## ADDENDUM NO. 1

**Date:** April 5, 2017

**Project:** Hall Elementary School  
Portland Public Schools/City of Portland  
Portland, Maine

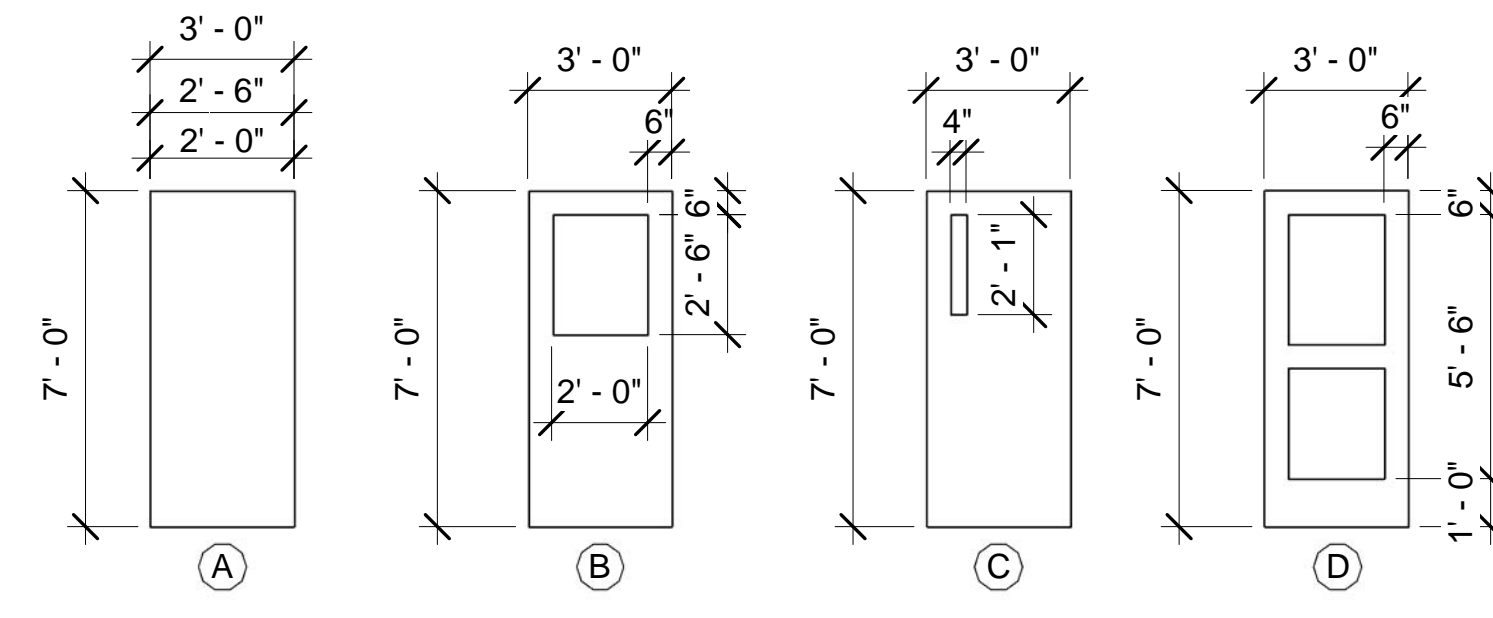
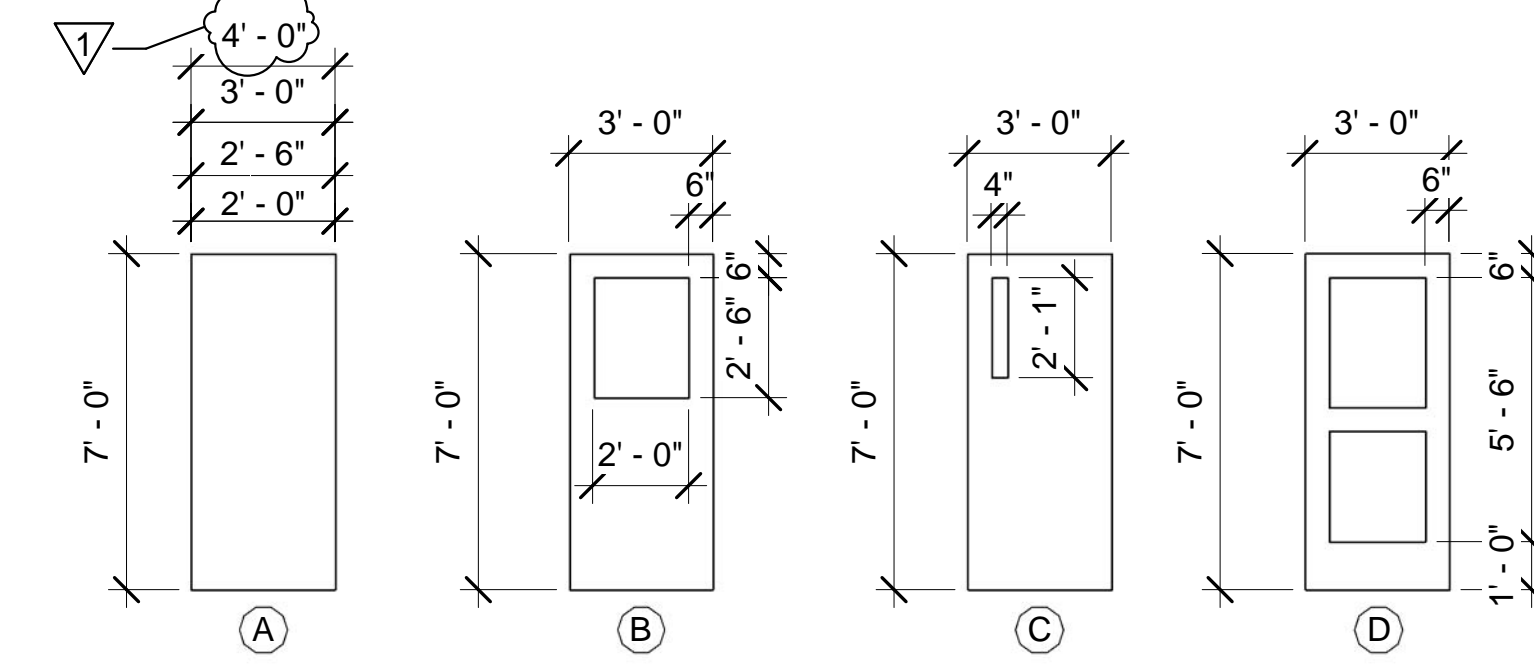
1. Door D15 Revise door thickness to 1-3/4”
2. Door D16 Revise door thickness to 1-3/4”
3. Door D18A Revise door thickness to 1-3/4”
4. Door D23 Revise door thickness to 1-3/4”
5. Door D23A Revise door thickness to 1-3/4”
6. Door D26 Revise door thickness to 1-3/4”
7. Door D26A Revise door thickness to 1-3/4”
8. Door D32 Revise door thickness to 1-3/4”

1 PAVEMENT MARKING, SIGNAGE, AND SITE CIRCULATION PLAN
 CM101 SCALE: 1"=50'

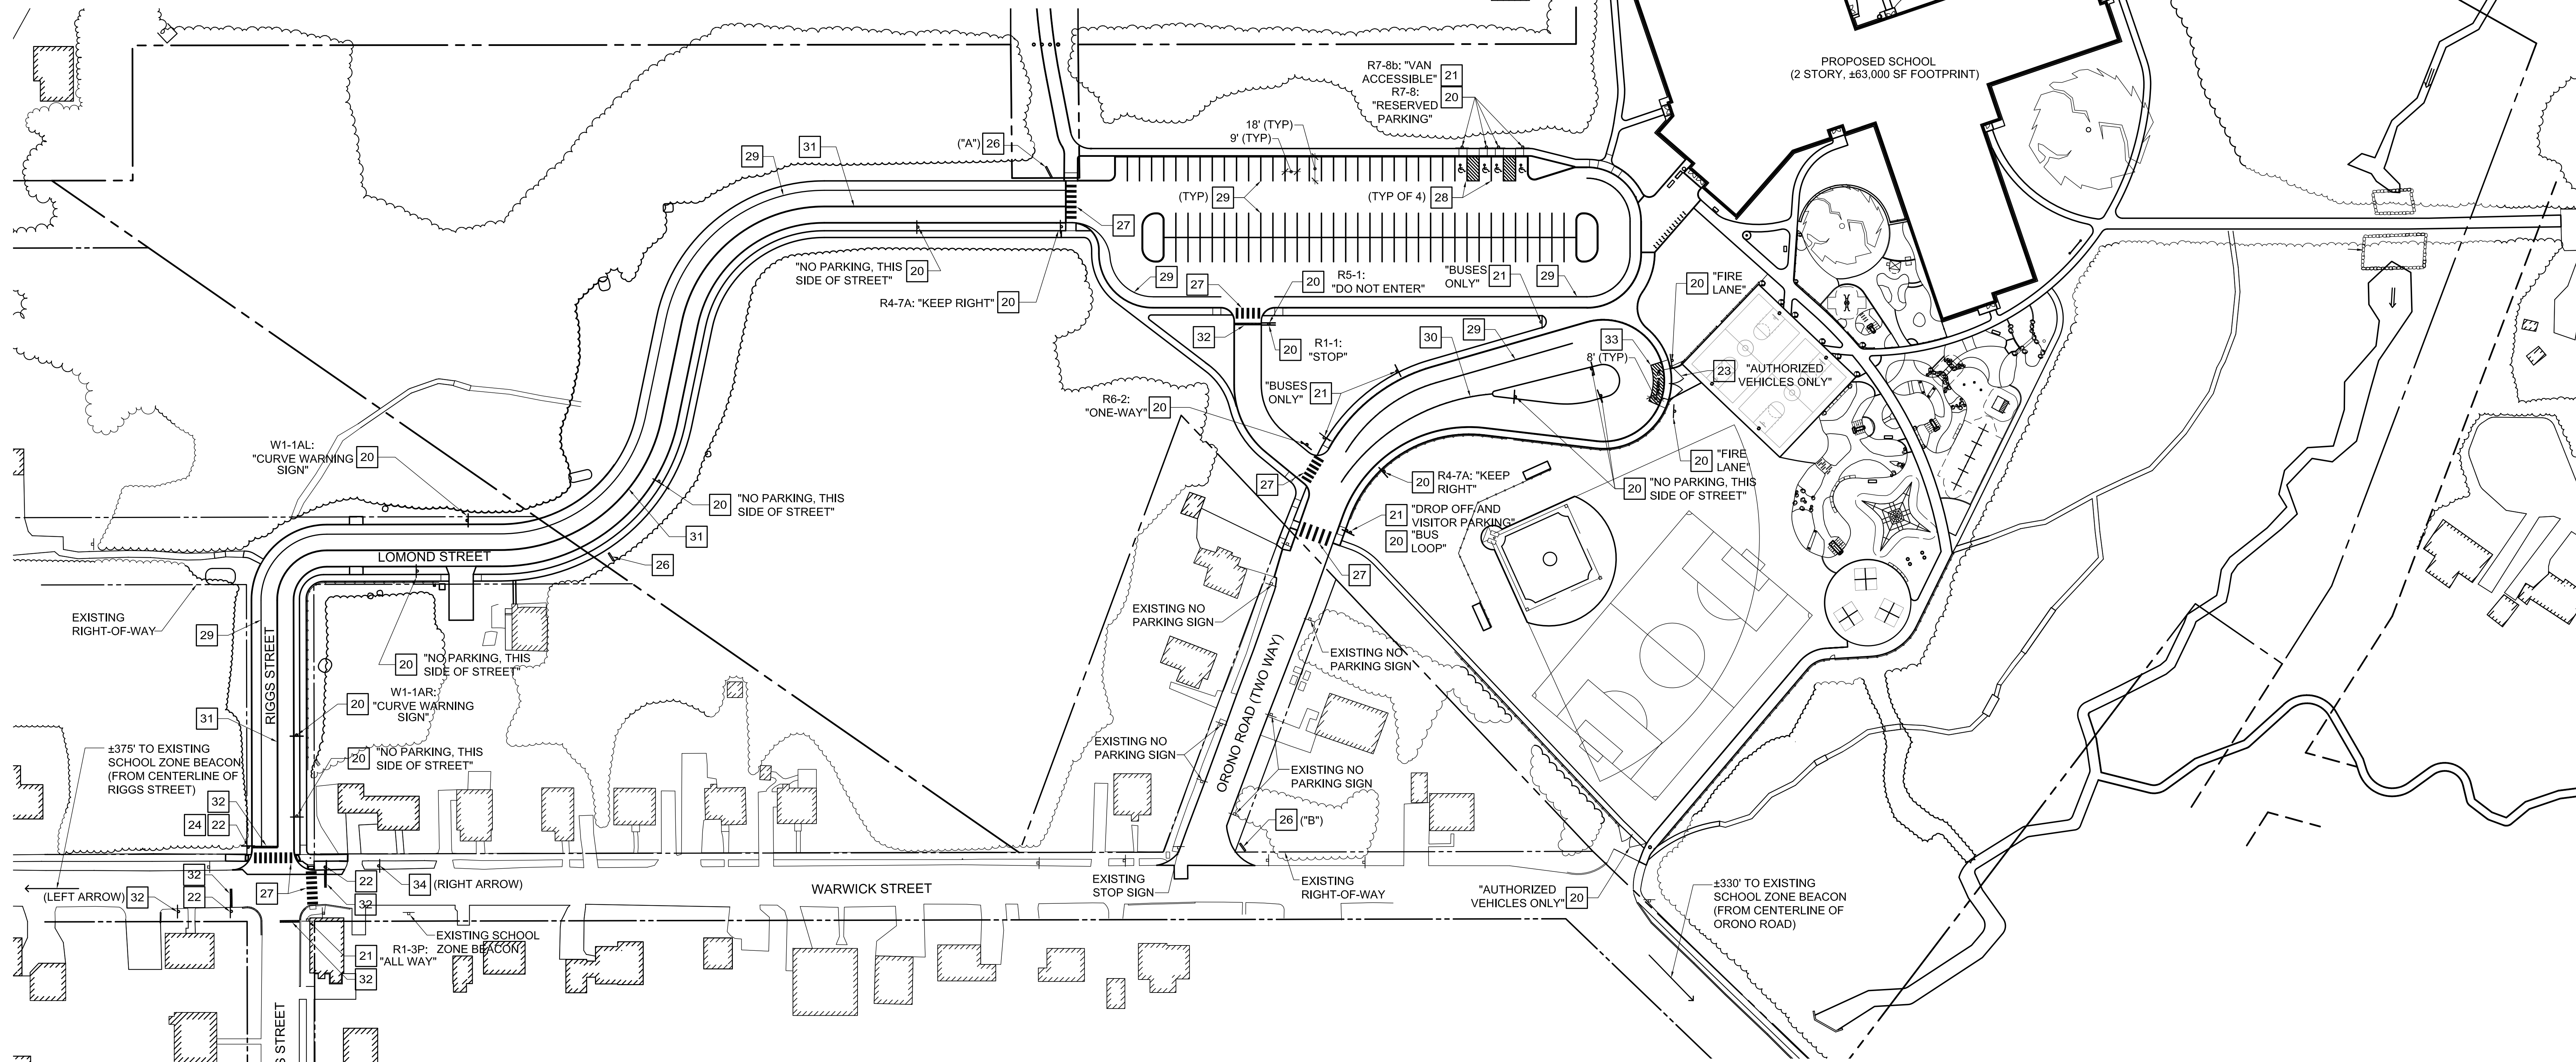
1. **DELETE** sheet in its entirety and **REPLACE** with attached sheet CM101. Sheet has been revised to reflect changes in signage within the bus loop, along the entrance drive from Riggs/Lomond Street and on Warwick Street.

**1 PHASING AND CONSTRUCTION MANAGEMENT PLAN-PHASE 1**  
 CP101 SCALE: 1"=50'

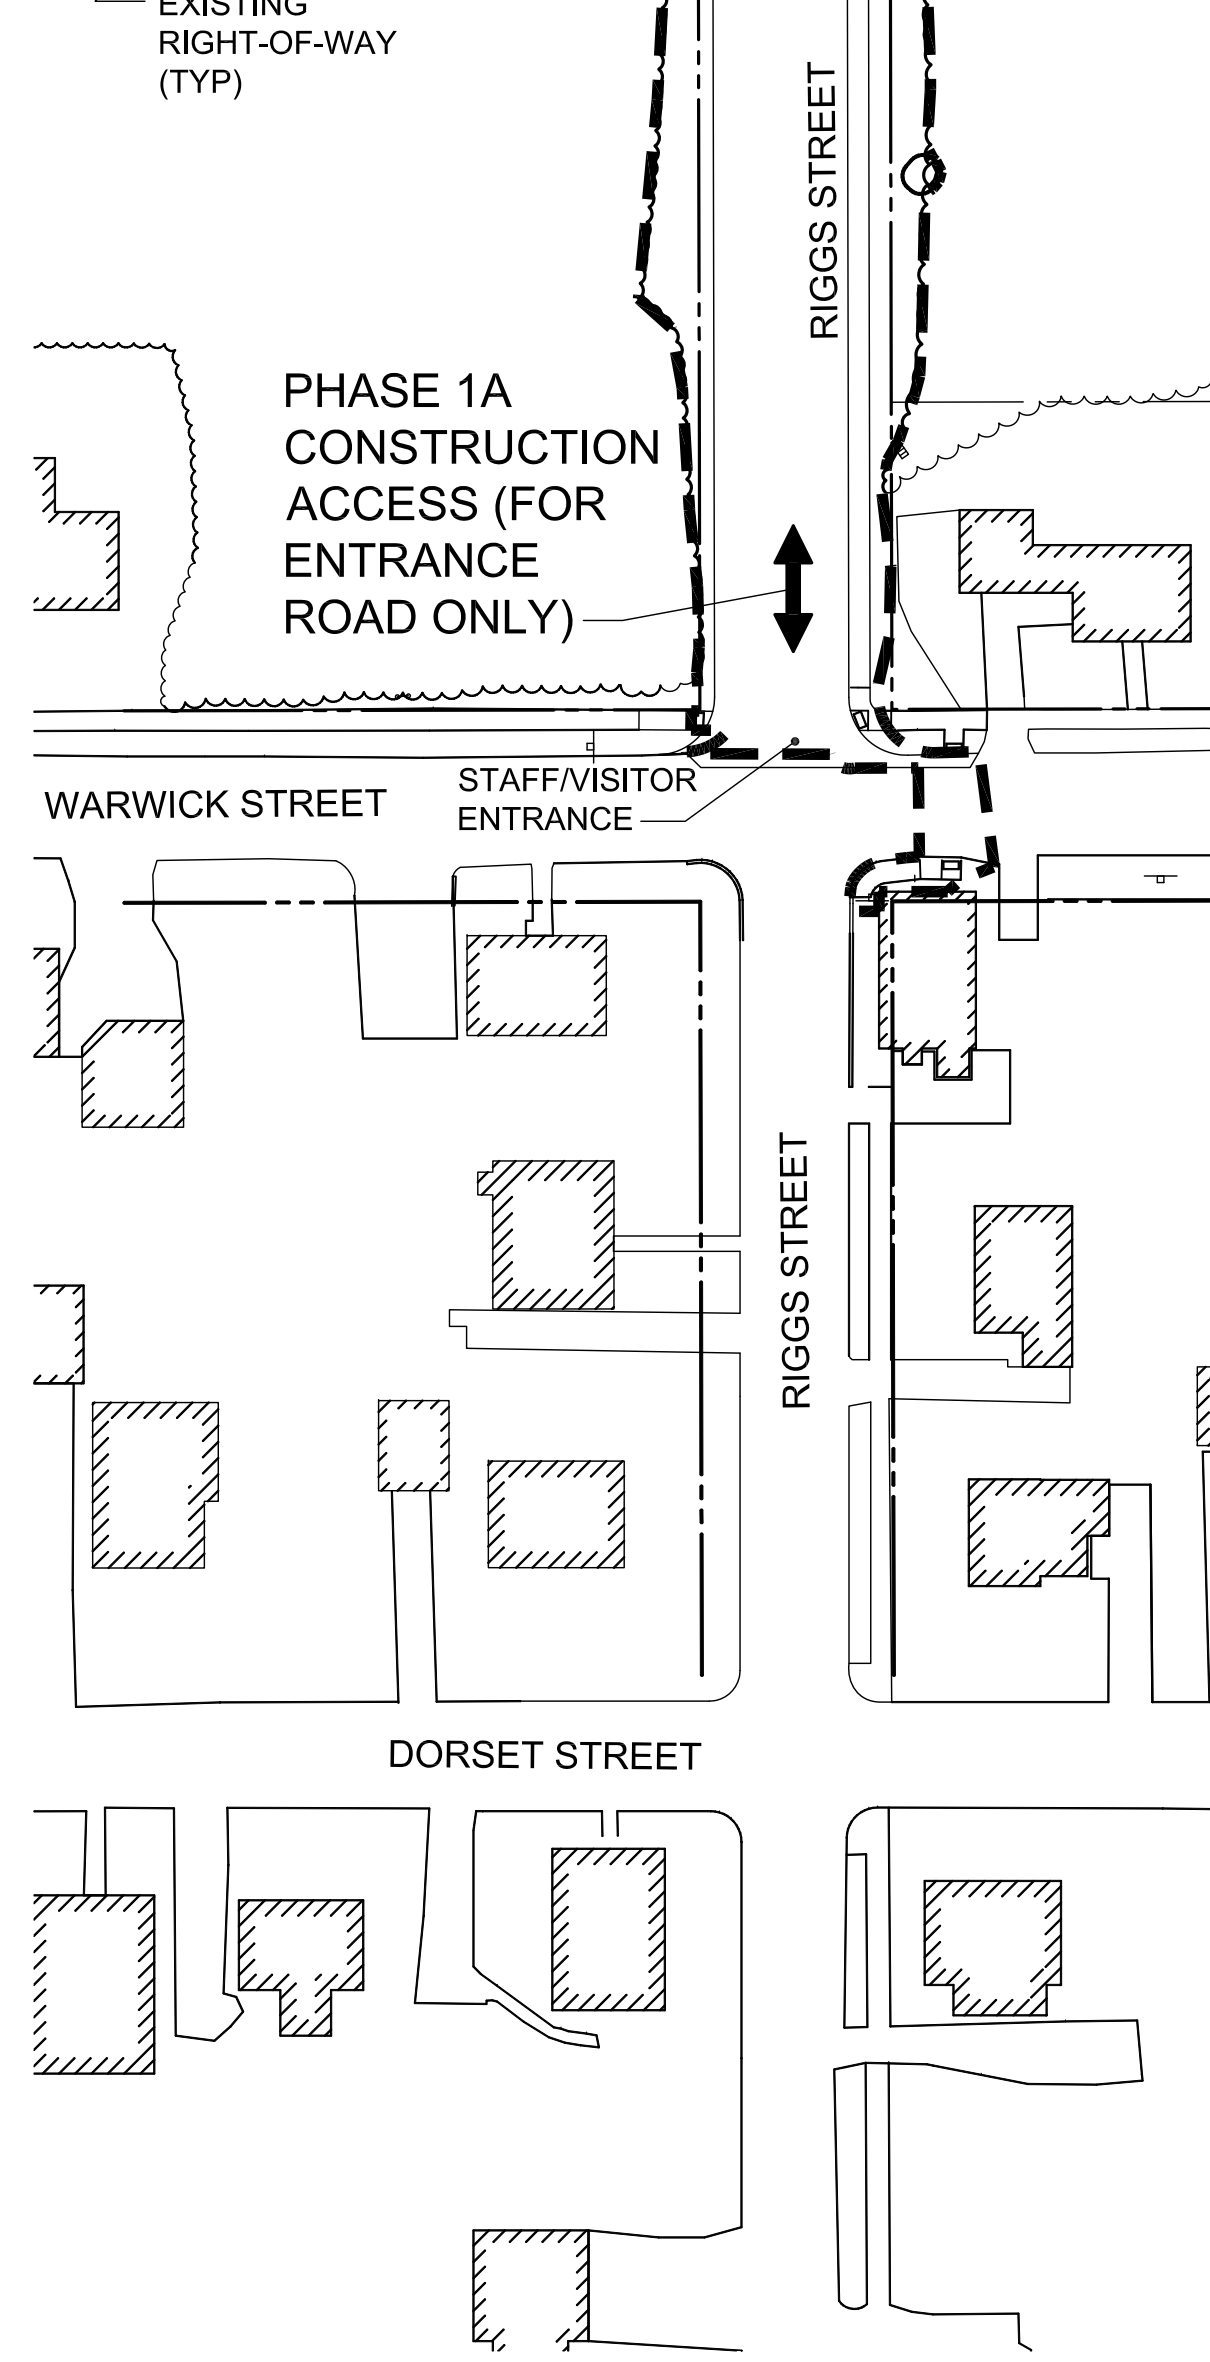
1. Tree removal work by the City of Portland consists of cutting down and removing trees only. All other items indicated on the drawings are the responsibility of the Contractor. This includes stump removal, erosion control, soil stabilization, construction entrances, etc.

1 SOUTH SITE PLAN-PHASE 1
SCALE: 1"=40'

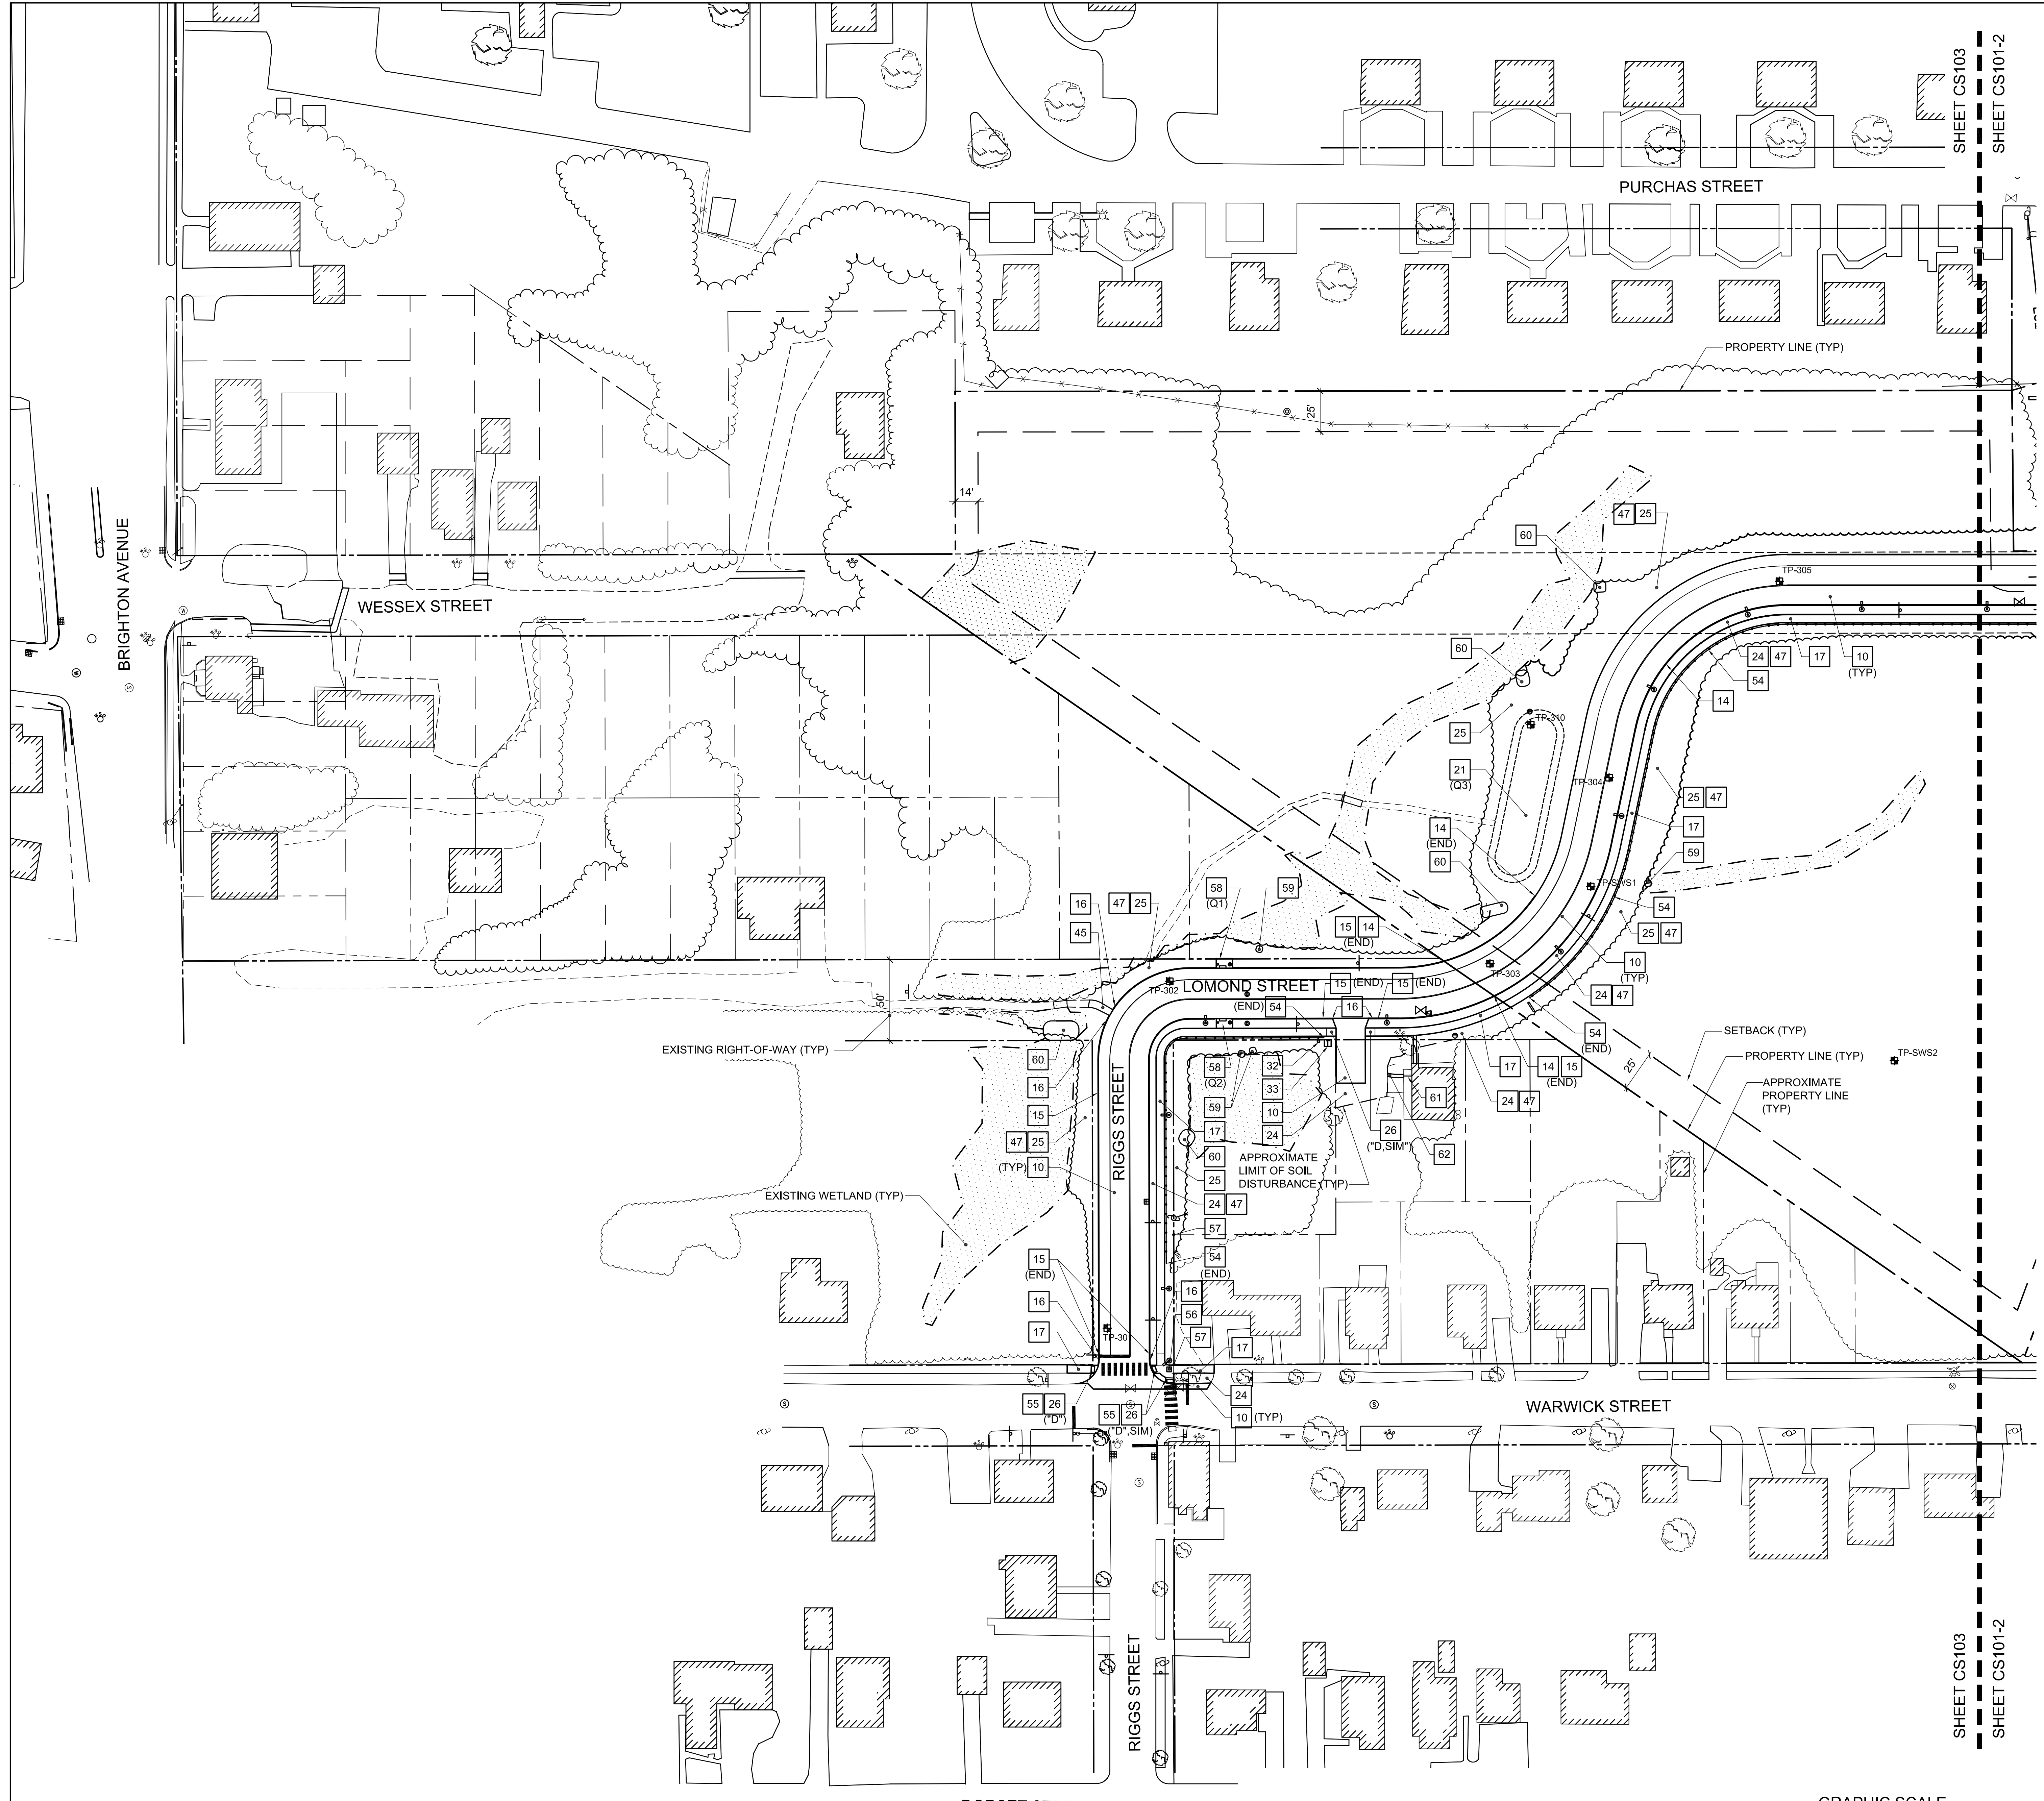
1. **DELETE** sheet in its entirety and **REPLACE** with attached sheet CS103. Sheet has been revised to reflect changes in Work required at the Riggs Street/Warwick Street intersection and changes to Riggs Street and Lomond Street widths.
